Date: 24 October 2024

**Planning Act 2008 (as amended) Section 89
The Infrastructure Planning (Examination Procedure) Rules 2010 (as amended) –
Rule 17**

**Application by RWE Renewables UK Dogger Bank South (West) Ltd and RWE
Renewables UK Dogger Bank South (East) Ltd for an Order granting Development
Consent for the Dogger Bank South Offshore Wind Farms**

Request for further information

Figure: 16-2 Drawing No: PC2340-RHD-OF-ZZ-DR-Z-0591

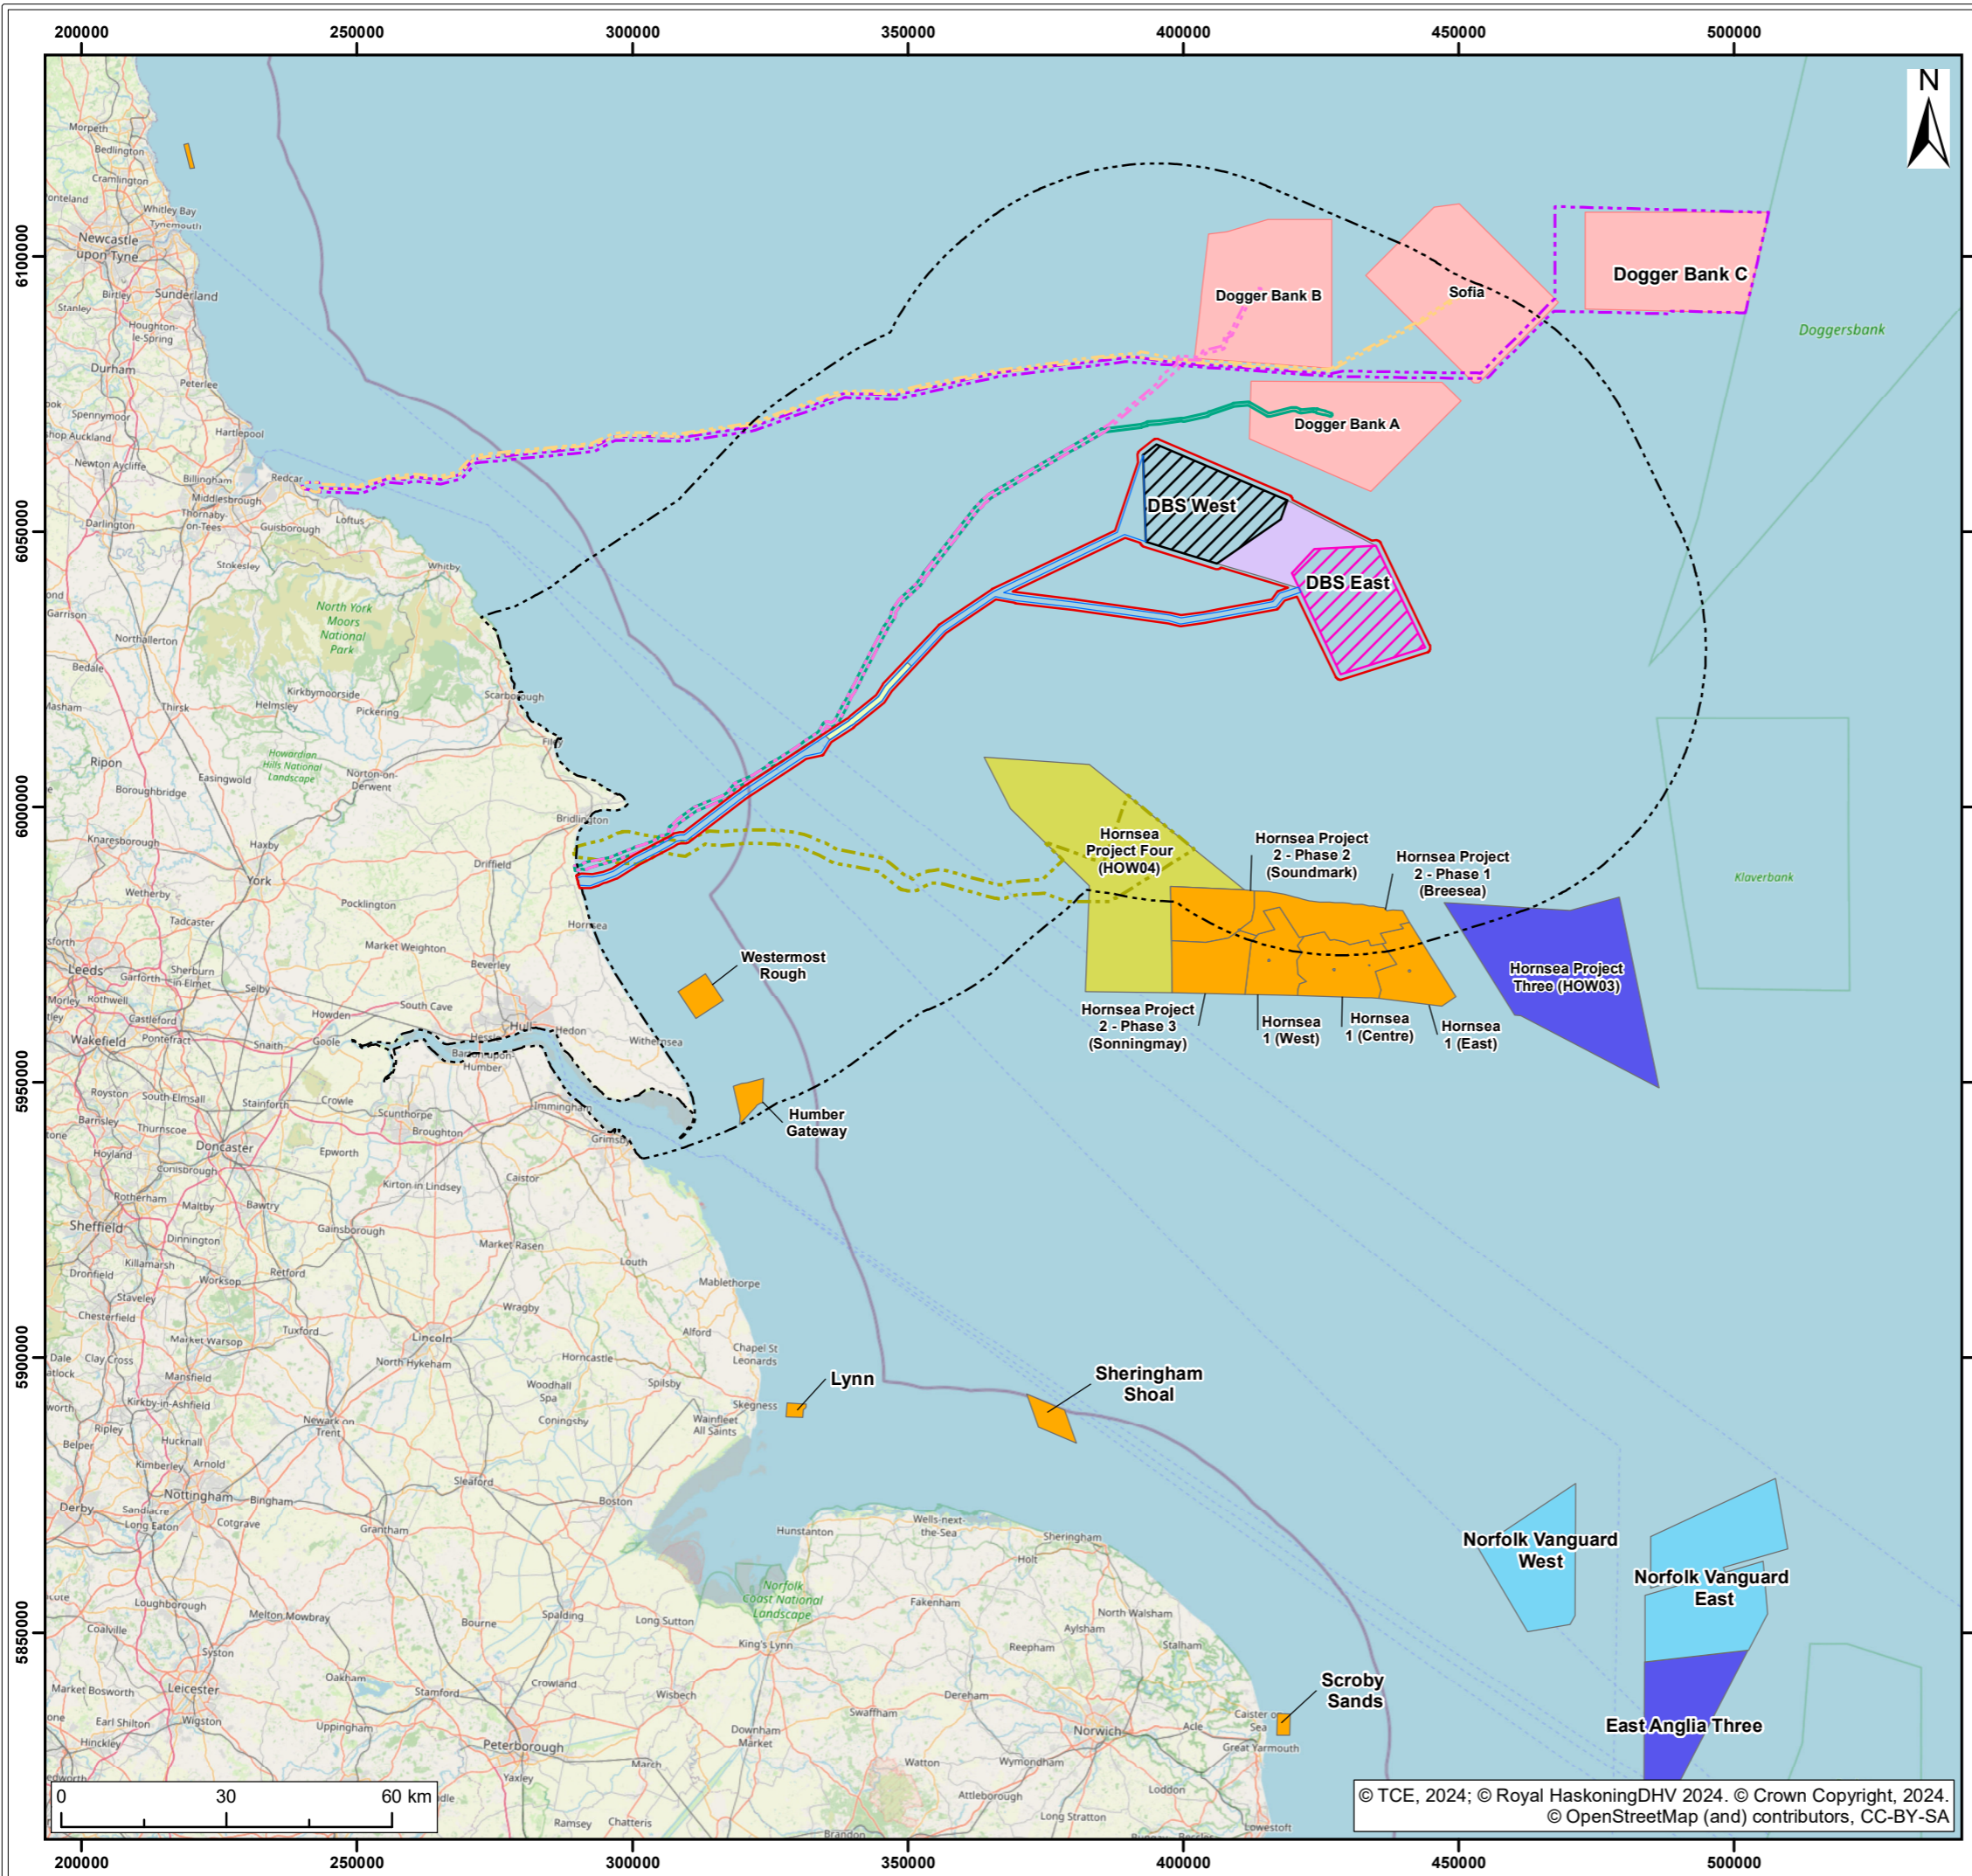
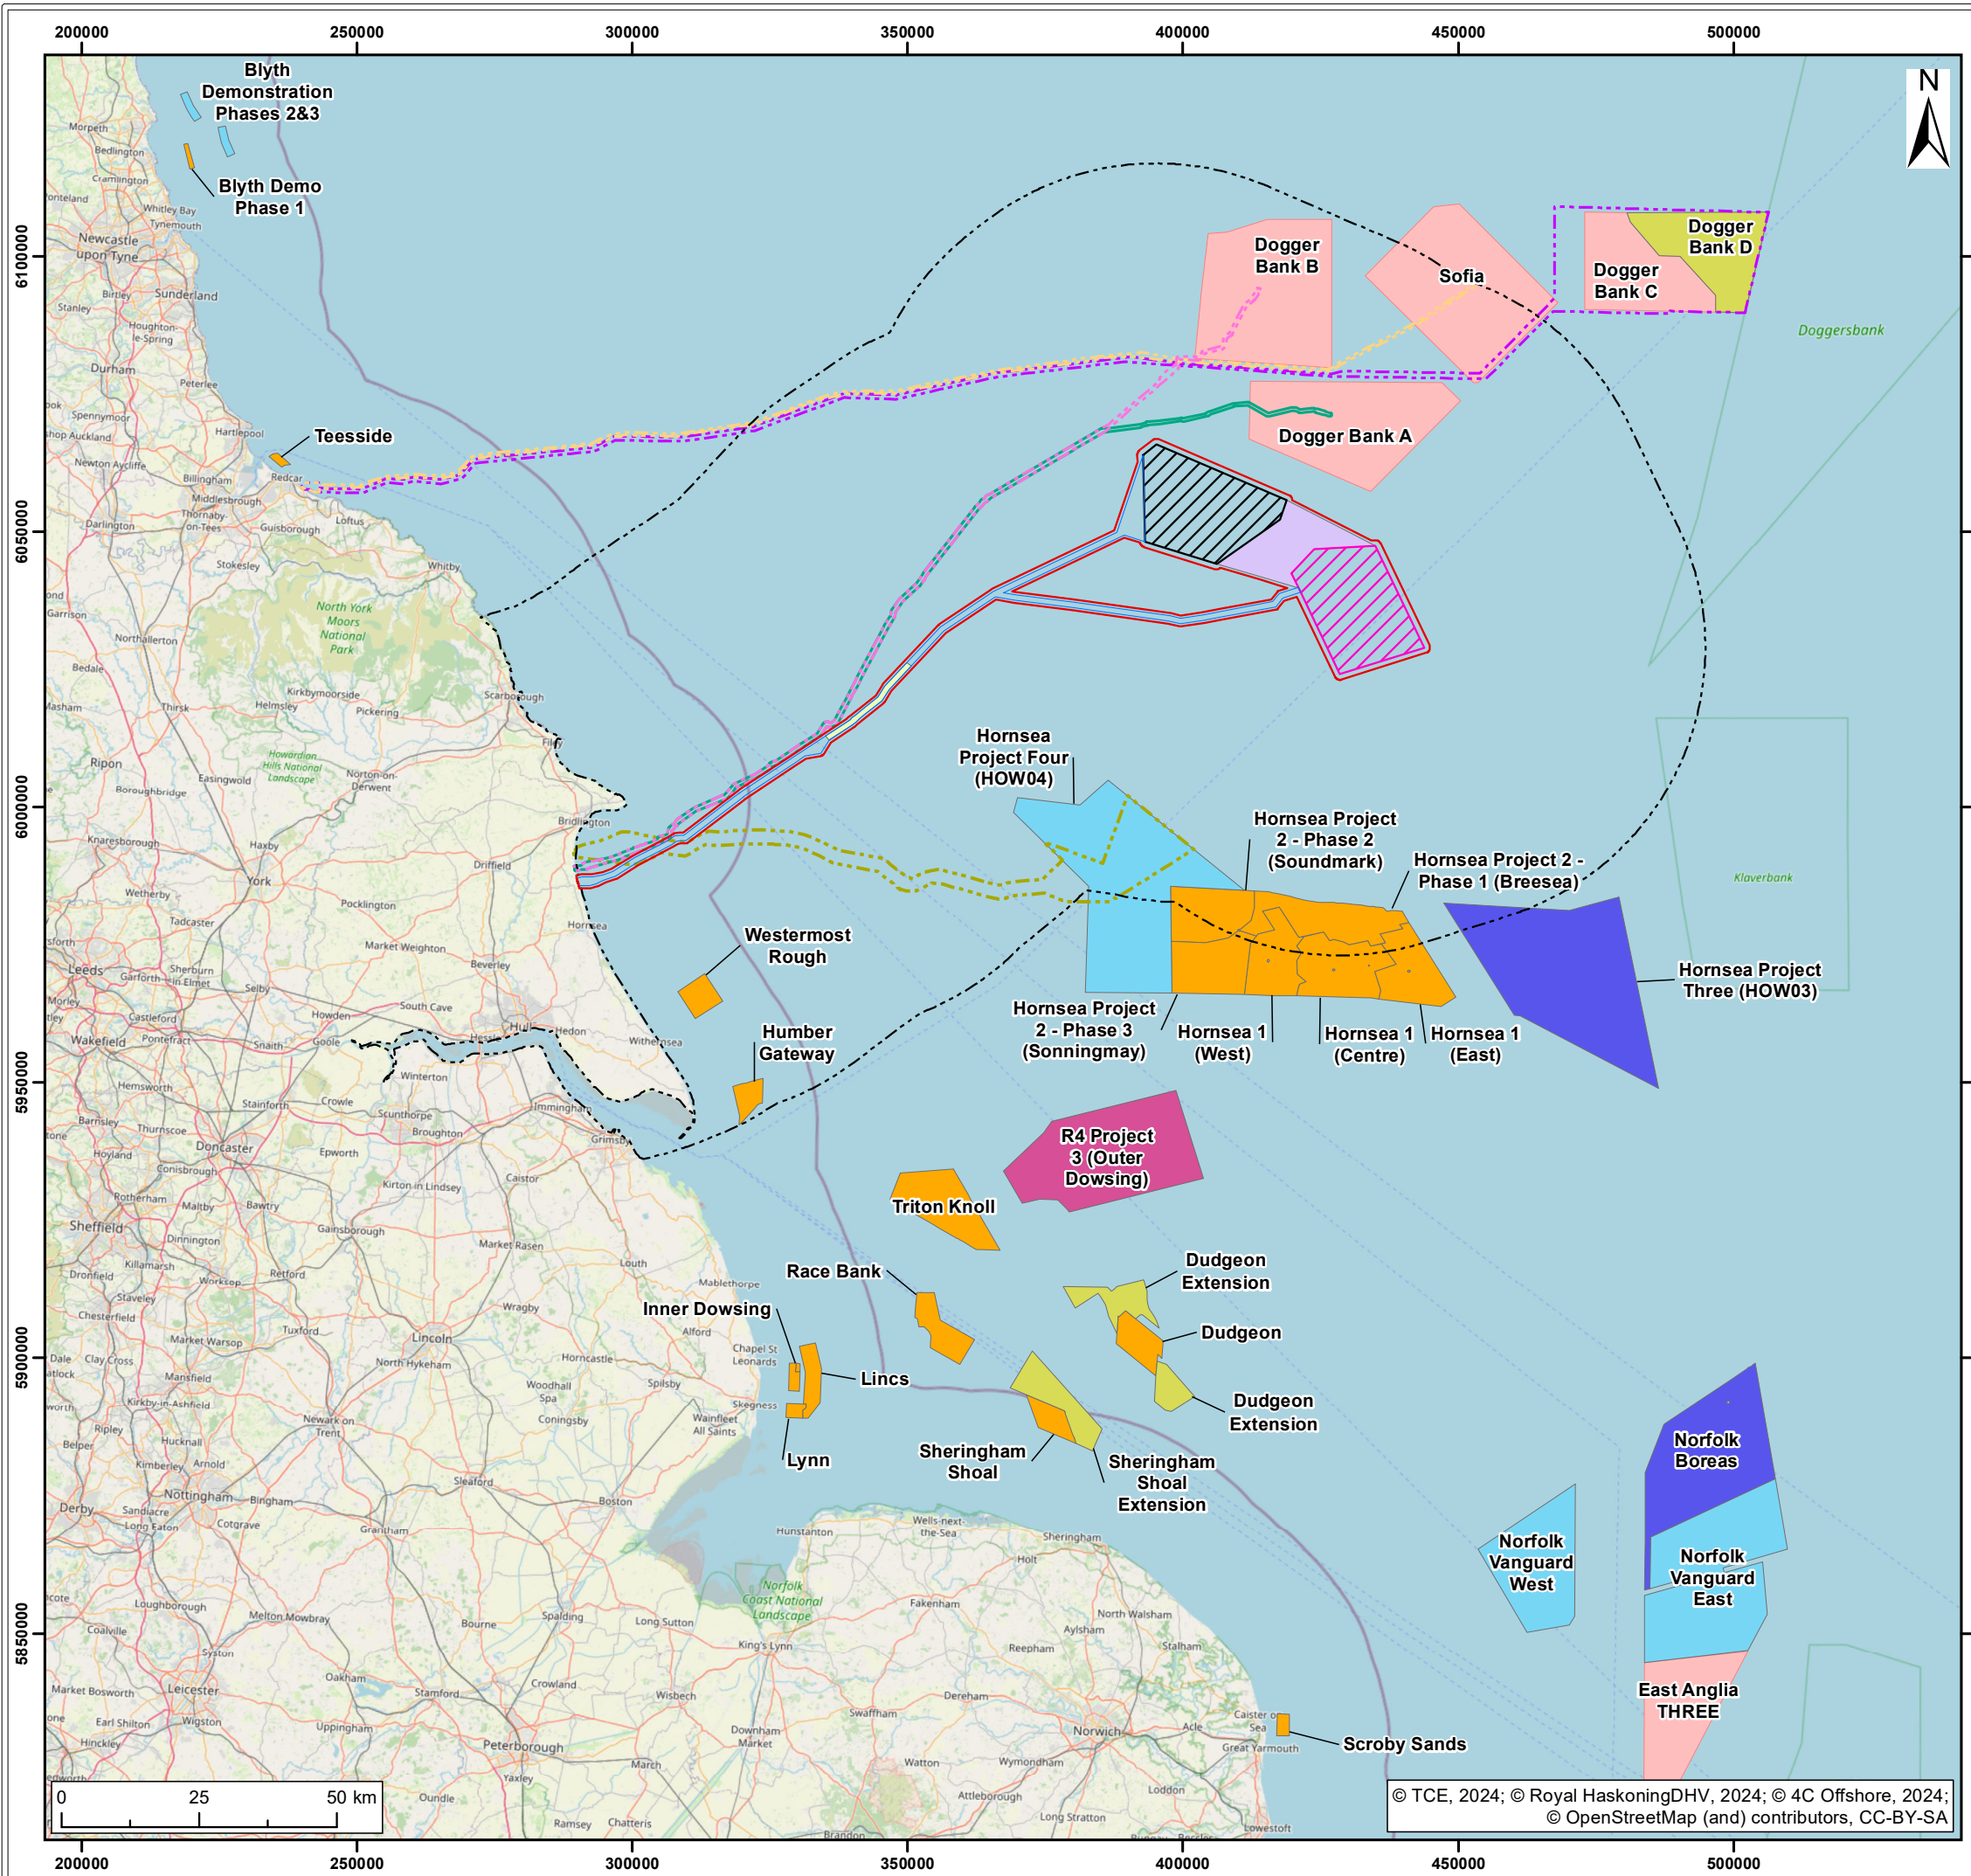
- ES Chapter 16 [APP-130, paragraph 37] states that the only offshore wind farm in planning is 'Dogger Bank D', however this is not shown on Figure 16-2 of [APP-131]. Furthermore, Figure 16-2 of [APP-131] shows 'Hornsea Project Four' as "in planning" which would appear to be incorrect as it is consented. Please review these documents and update and amend as necessary.
